Reference: 23016

**Re: 20 Kelso Crescent, Moorebank (SSD-58978472) – Traffic Response to RFI**

I have considered the relevant traffic and parking matters from TfNSW, NSW Department of Planning and the Environment (DPE), Liverpool City Council and Public Submission.

Drawing Title:
GROUND FLOOR PLAN

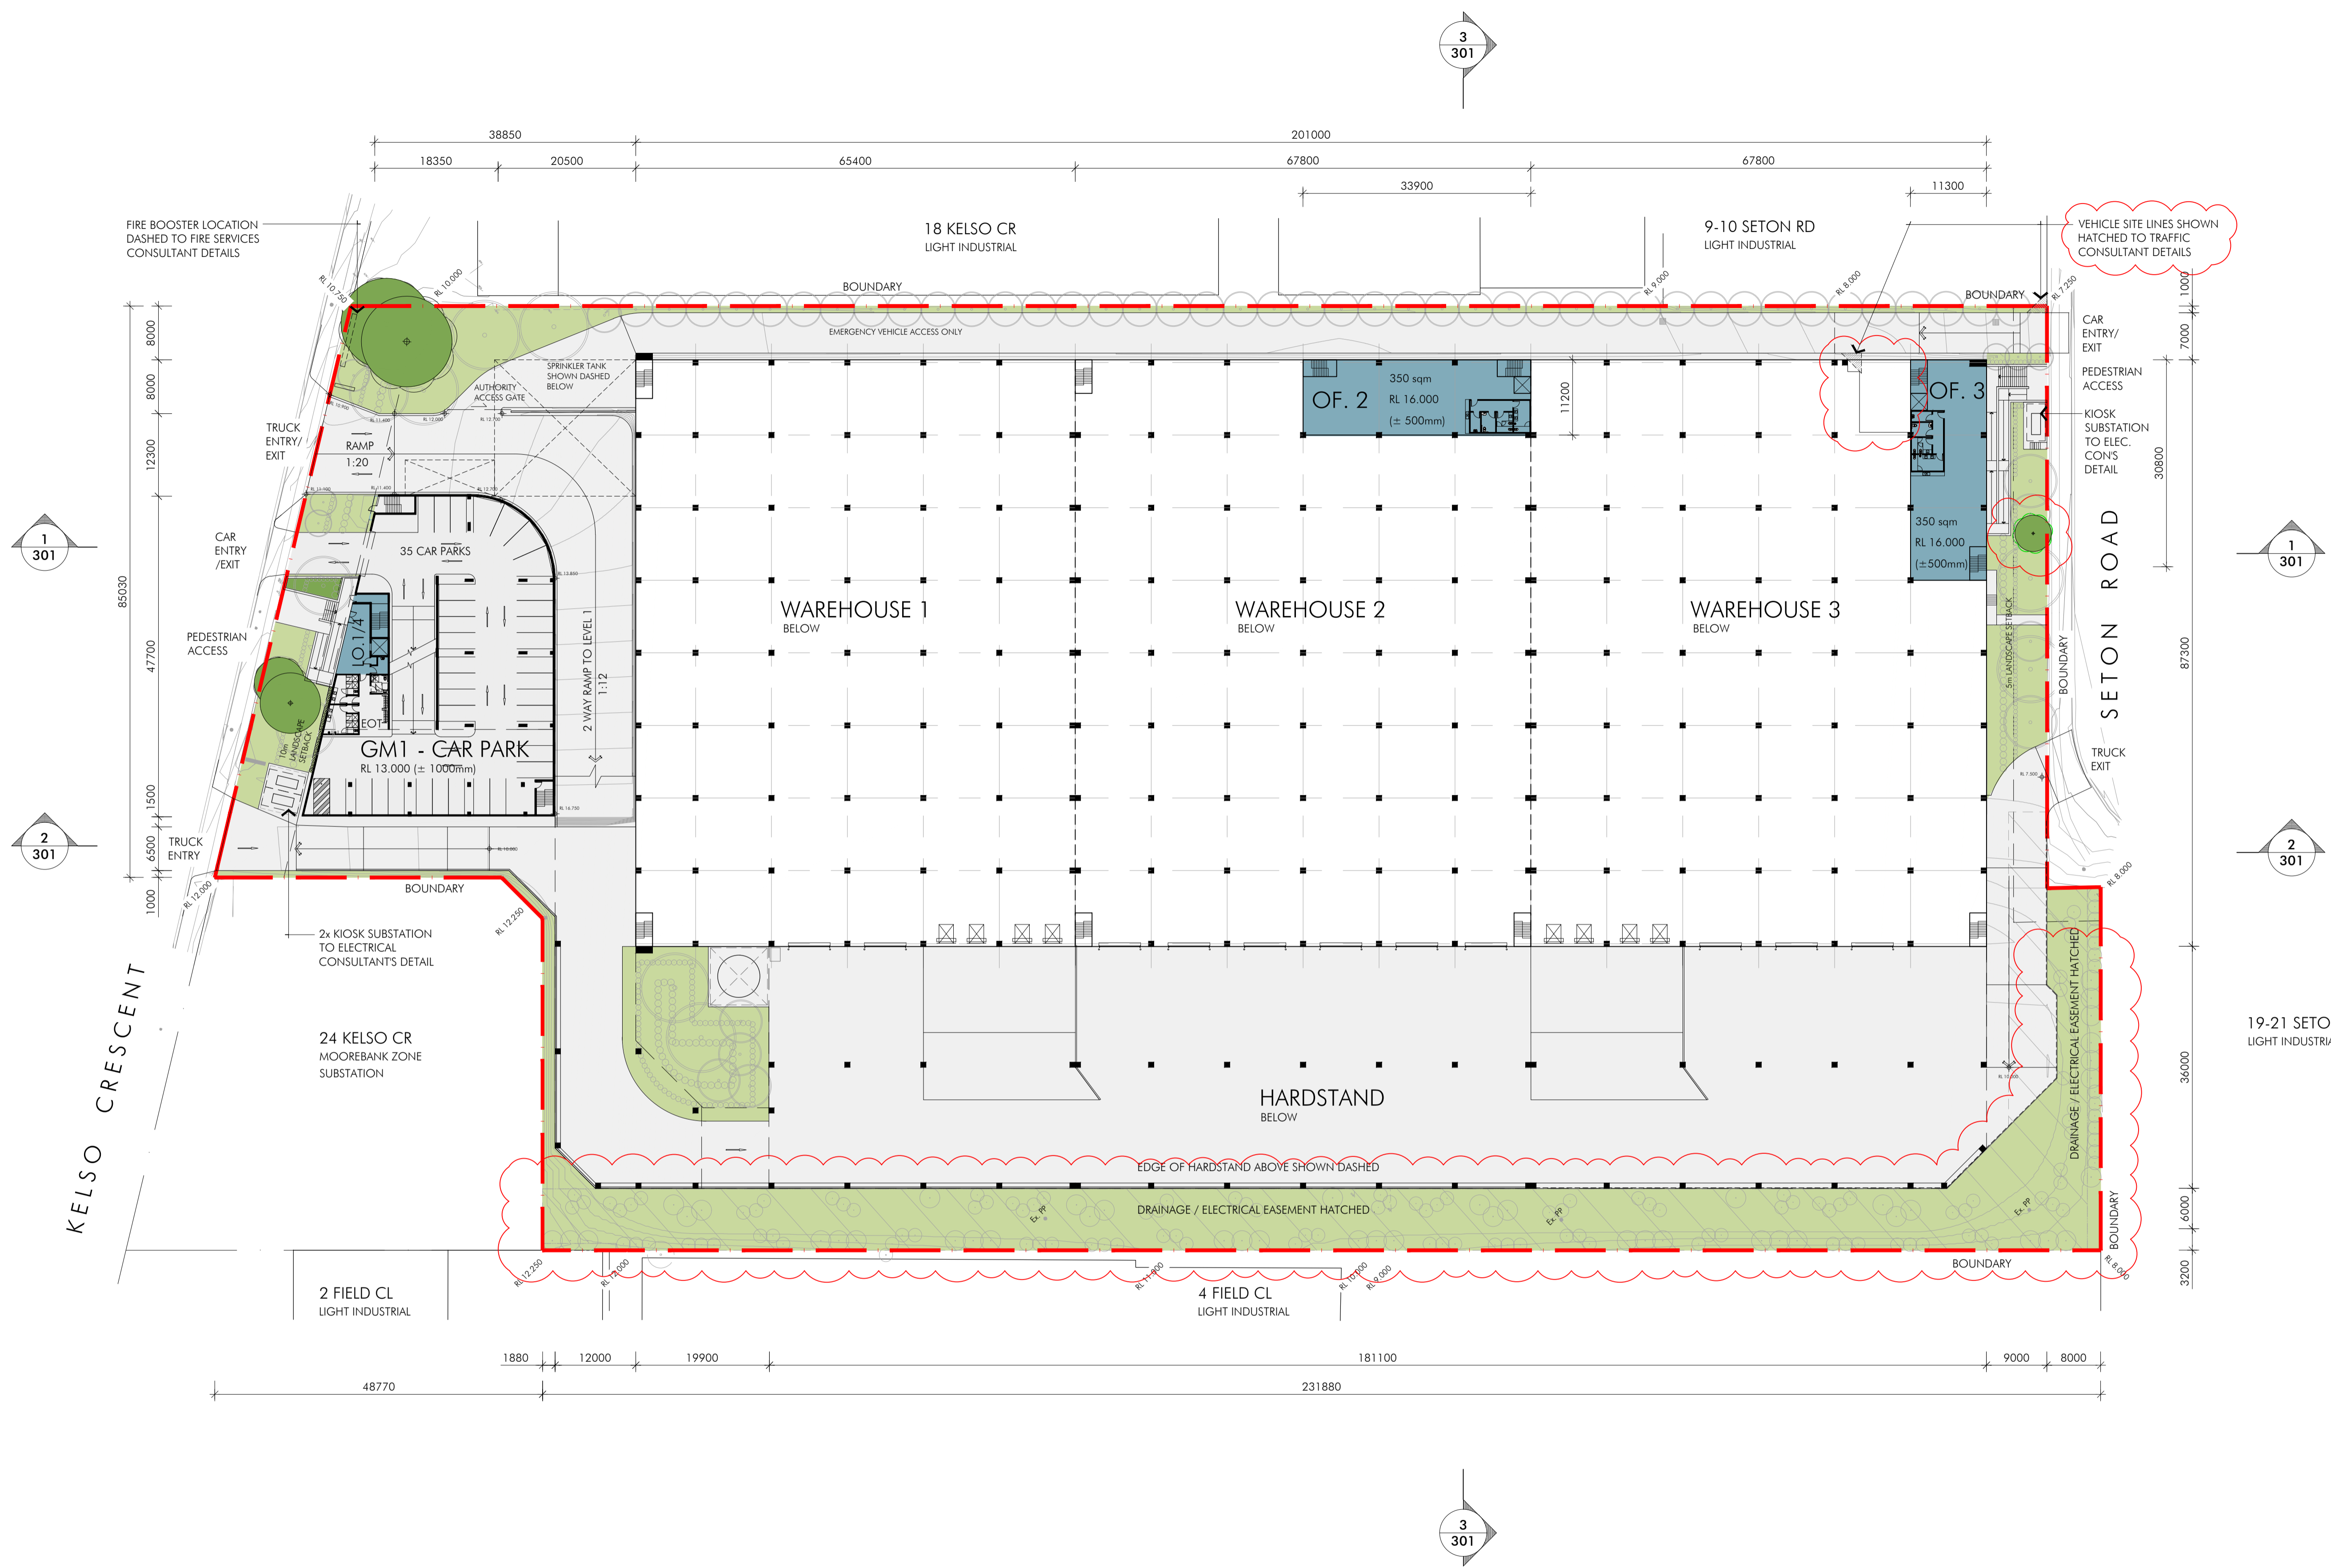
*According to the TIA, it is proposed to provide (5) new access driveways, three on Kelso Crescent and two on Seton Road. All light vehicles will access the car park via the northern access at Kelso Crescent and southern access at Seton Road. Truck access to the site involves Kelso Crescent (entry only) and Seton Road (exit only) for those destined to the ground floor. It also proposes entry and exit for trucks via Kelso Crescent to Level 1 Warehouses.*

*The proposed five (5) driveways is excessive and will reduce the availability of on-street parking. Google maps show a high level of occupancy of on-street parking on the streets fronting the development site. It is requested the proposal reduce the number of access driveways. For instance, the proposed truck entry access on Kelso Crescent near the intersection with Newbridge Road can be amalgamated with the second access for trucks away from the intersection.*

Architectural advice provided to this Office confirms that the design cannot physically accommodate a consolidated driveway arrangement on the Kelso Crescent frontage (as suggested in the above comments). This is due to different levels (one ramp leading to the first level; another on the ground level).

Our desktop assessment (Table 6 - overleaf) reveals the potential loss of up to 4 parking spaces on the street. If the Council's recommendation is implemented, i.e. consolidating the two driveways on Kelso Crescent, the loss would likely be 3 spaces (savings of 1 space). It is our view that the quantum lost (4 spaces) is not significant. Notwithstanding, if it is deemed necessary, the applicant is amenable to commission a brief survey of the surrounding car park to record the existing car parking spaces' supply and demand to determine whether the anticipated loss will be adverse to the local area.
